From: Cornelis Duba <Cornelis.Duba@endeavourenergy.com.au>
Sent: Friday, 30 April 2021 4:30 PM
To: Christopher Fraser
Cc: DPE CSE Information Planning Mailbox; Jeff Smith
Subject: NSW Planning, Industry & Environment Response to Submissions S29/3/97-Mod-1 Modification to 50 Peter Brock Drive, Eastern Creek – Event Parking Area

I refer to the Department's letter of 16 April 2021 advising of the Response to Submissions for State Significant Development DA S29-3-97-Mod-at 50 Peter Brock Drive, Eastern Creek (Lot 4 DP 1079897) for 'Modification of the Event Parking Area involves: regularising earthworks for an existing on grade event carparking area; sealing of the event car park, retaining wall and minor filling in the north-east corner of the event carpark; landscaping of earth batters; regularising stormwater works associated with the event carpark; additional stormwater works including installation of pipes, drainage pits and the addition and retention of drainage swales'. Submissions need to be made to the Department by 30 April 2021.

2.4. Endeavour Energy (Email Submissions)

CLIENT:
Martens & Associates Pty Ltd
PLAN REFERENCE:
6334-CATENARY 2

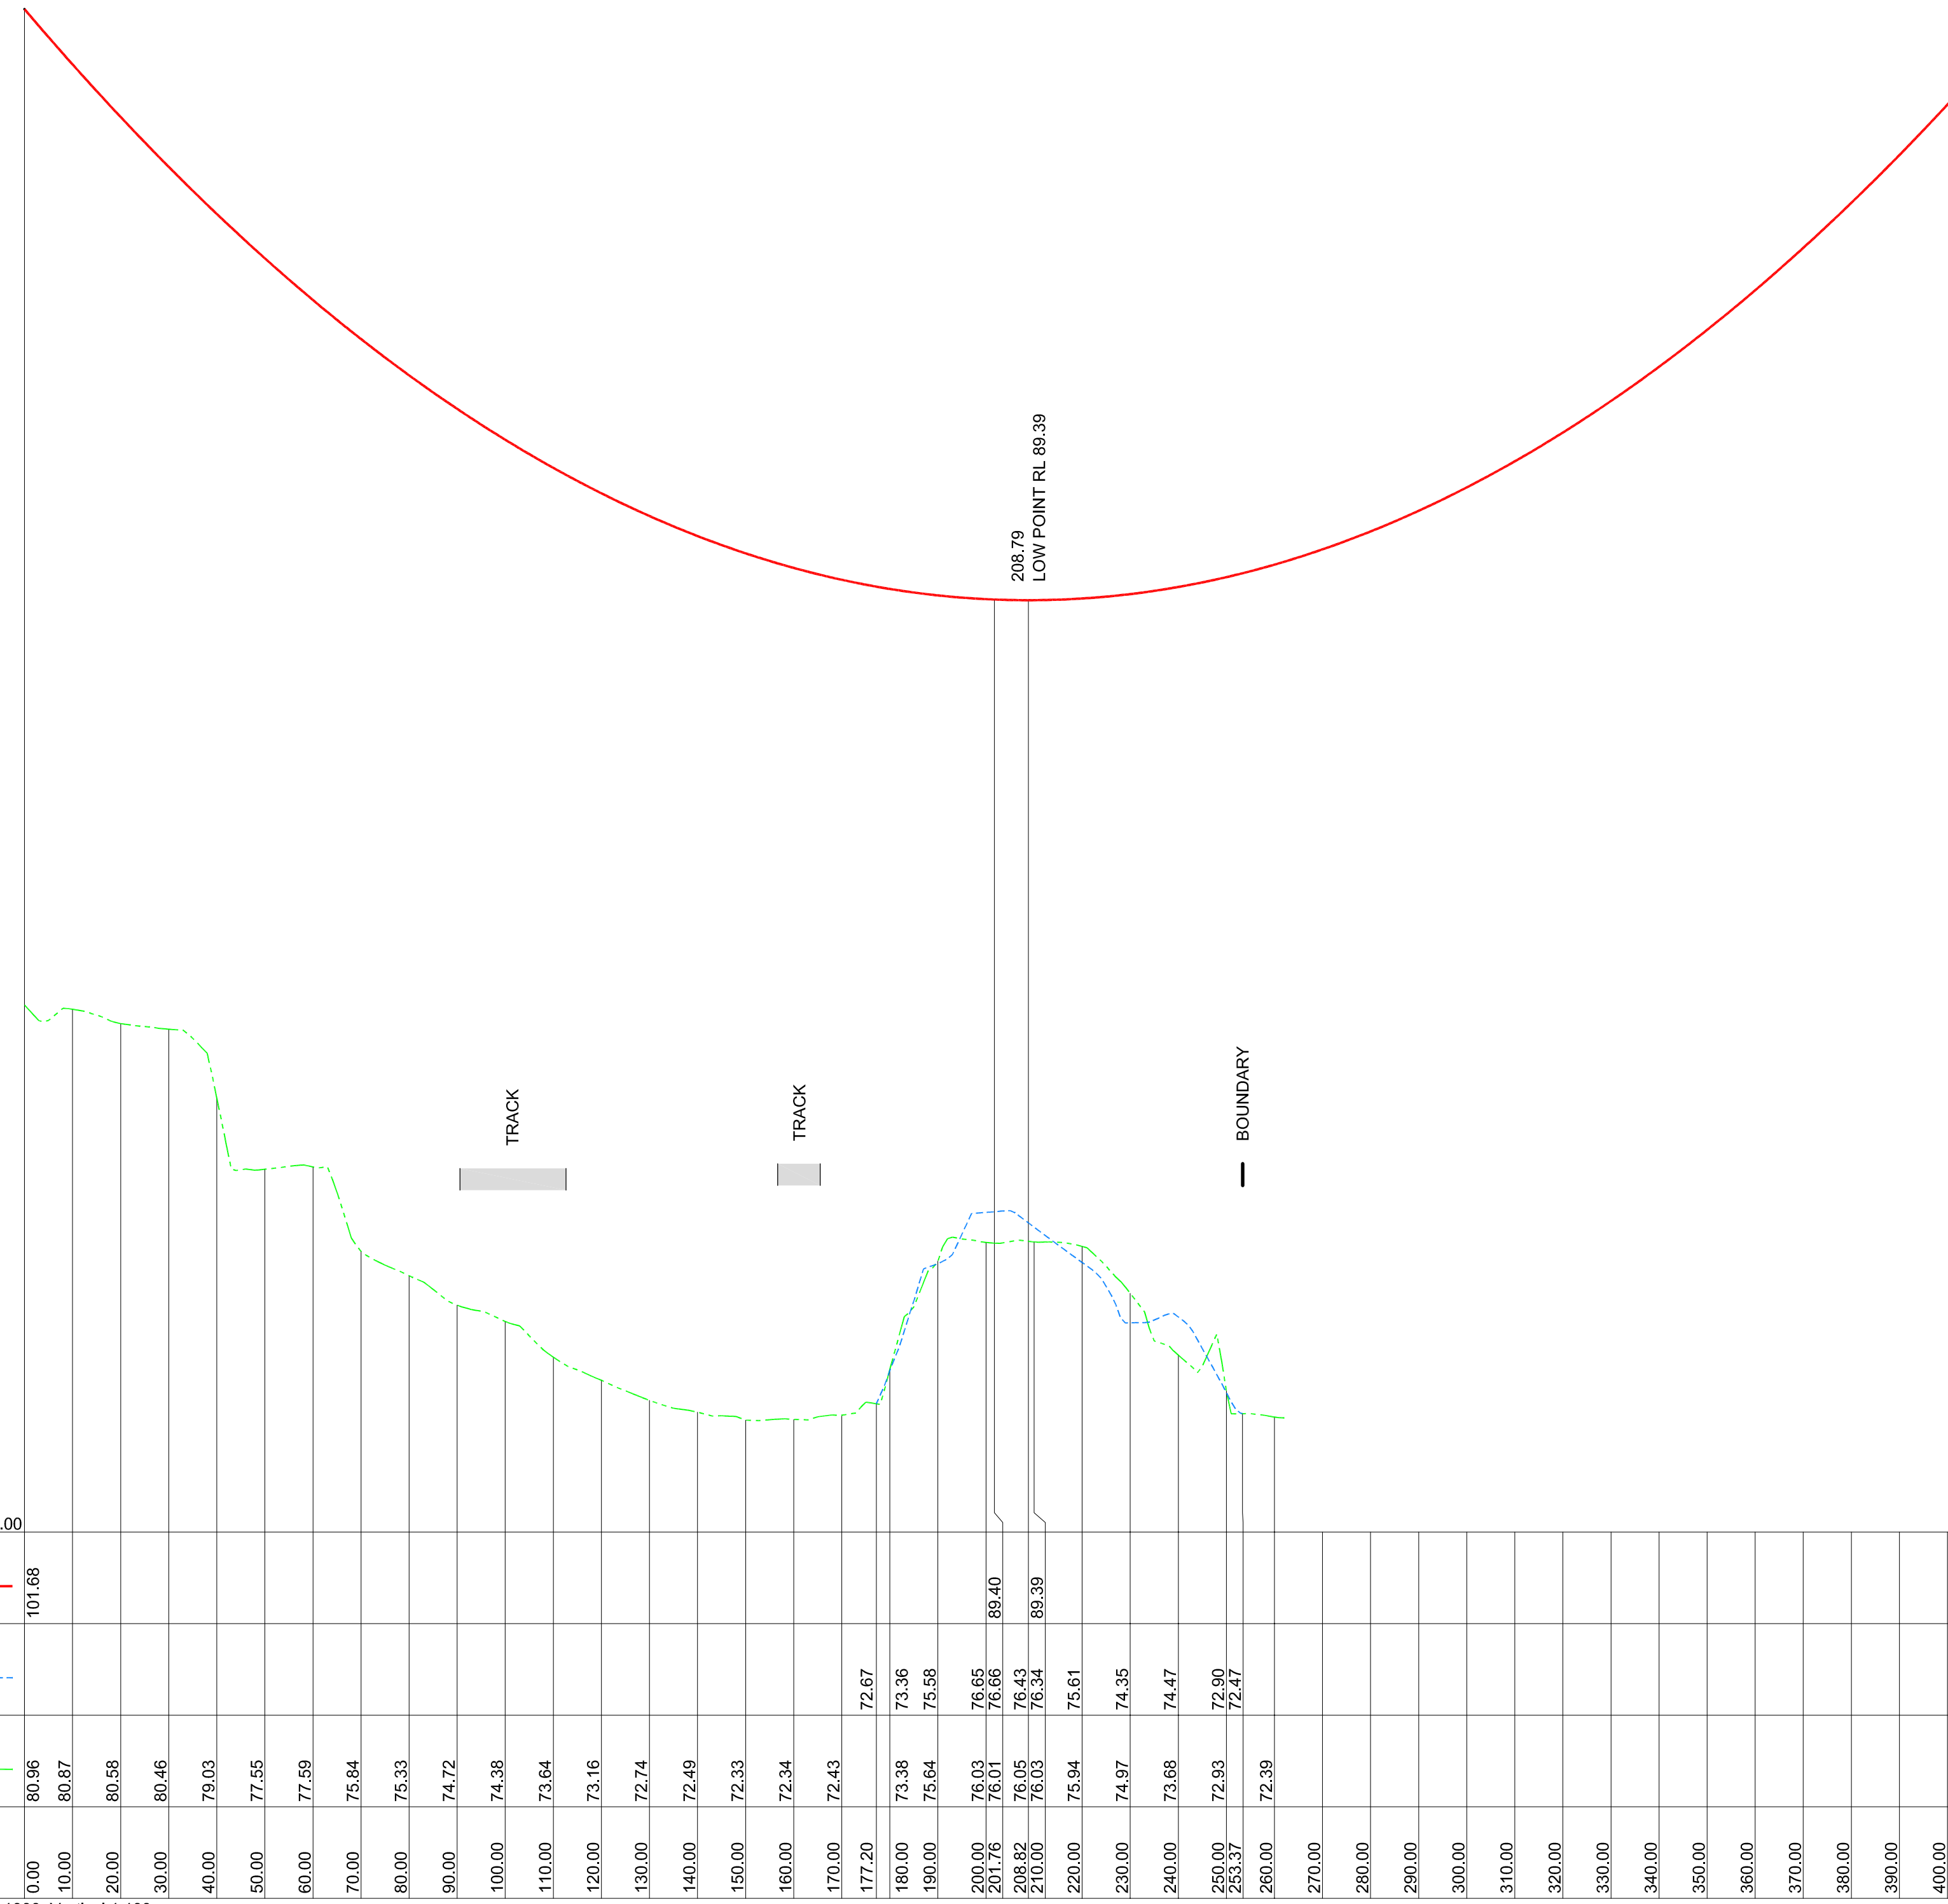
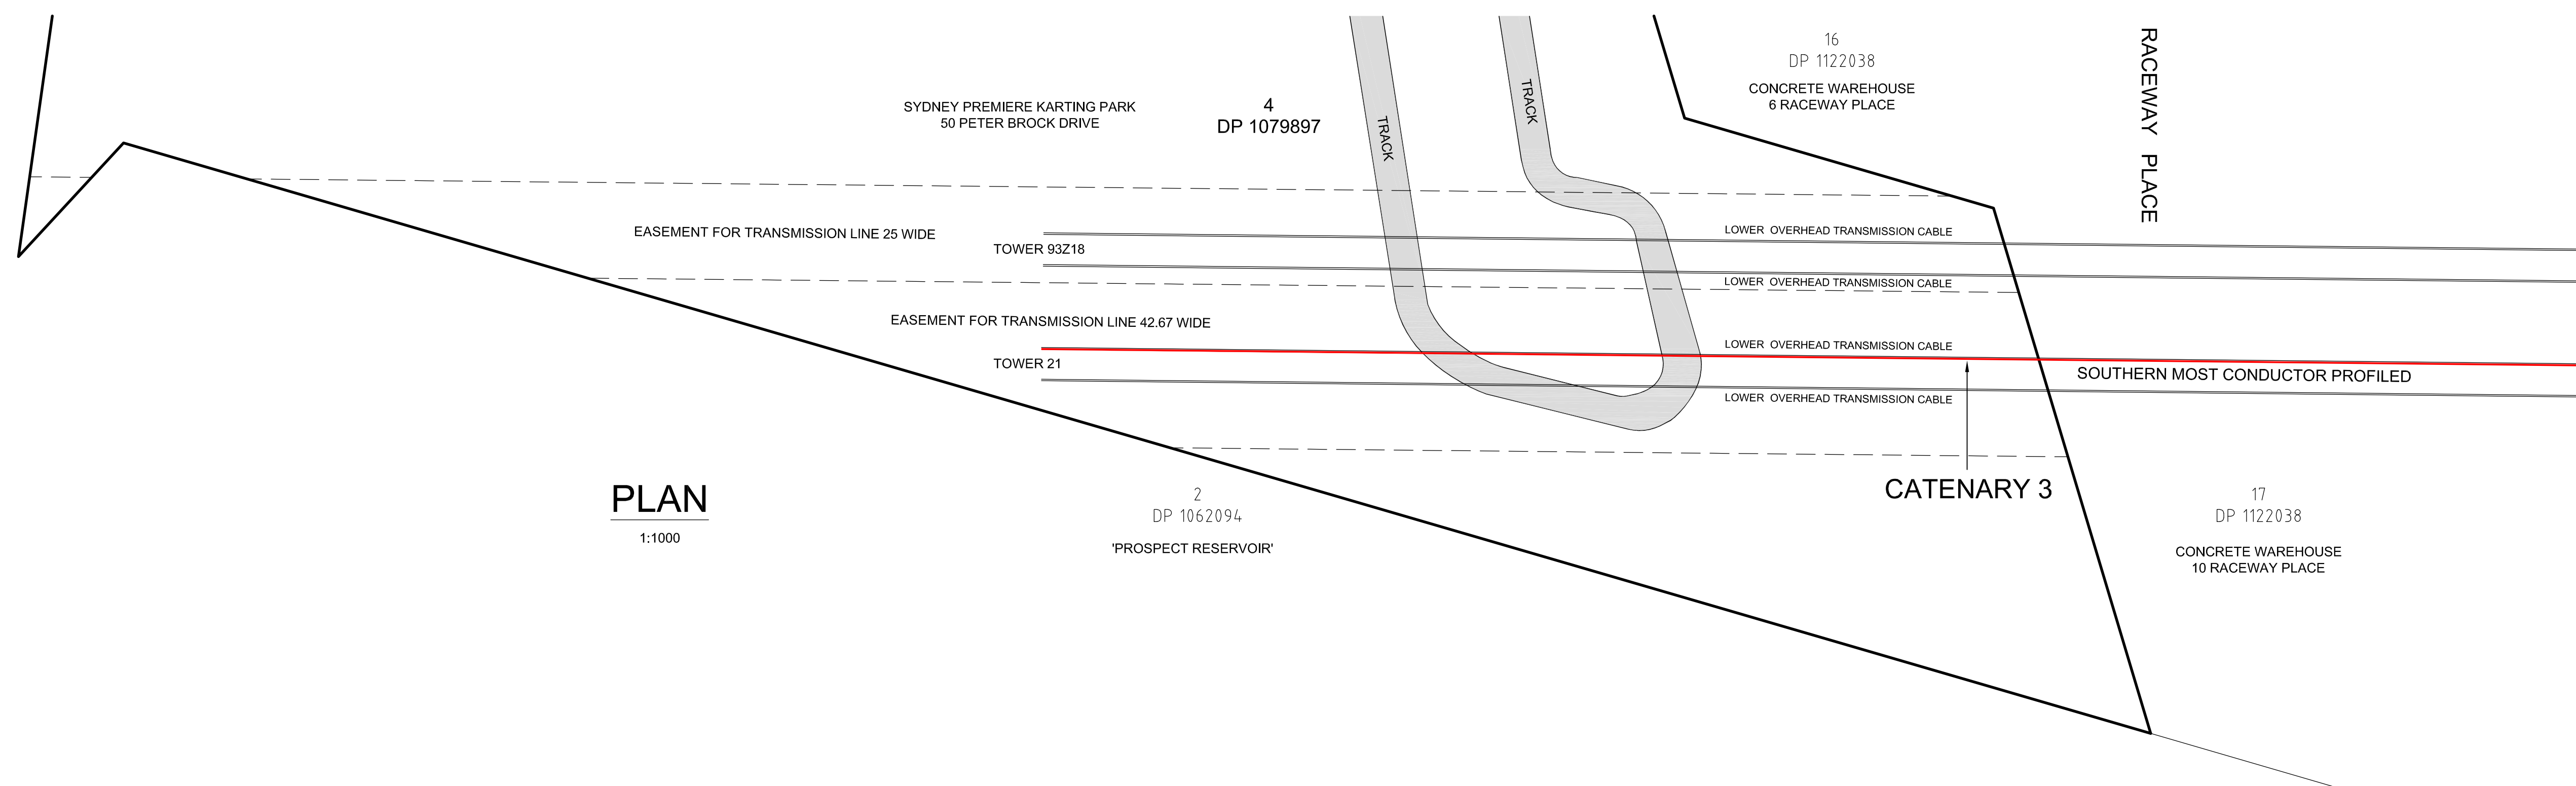
- a) The most recent survey showing centreline profile of the transmission lines over the Event Carpark area (Usher & Company Plan ref 6334-Catenary 1, 2, 3, 4, 11.03.2021) appears generally acceptable but is to have the proposed minor carpark regrading works ground profile superimposed over the surveyed profile and forwarded for EE sign off.
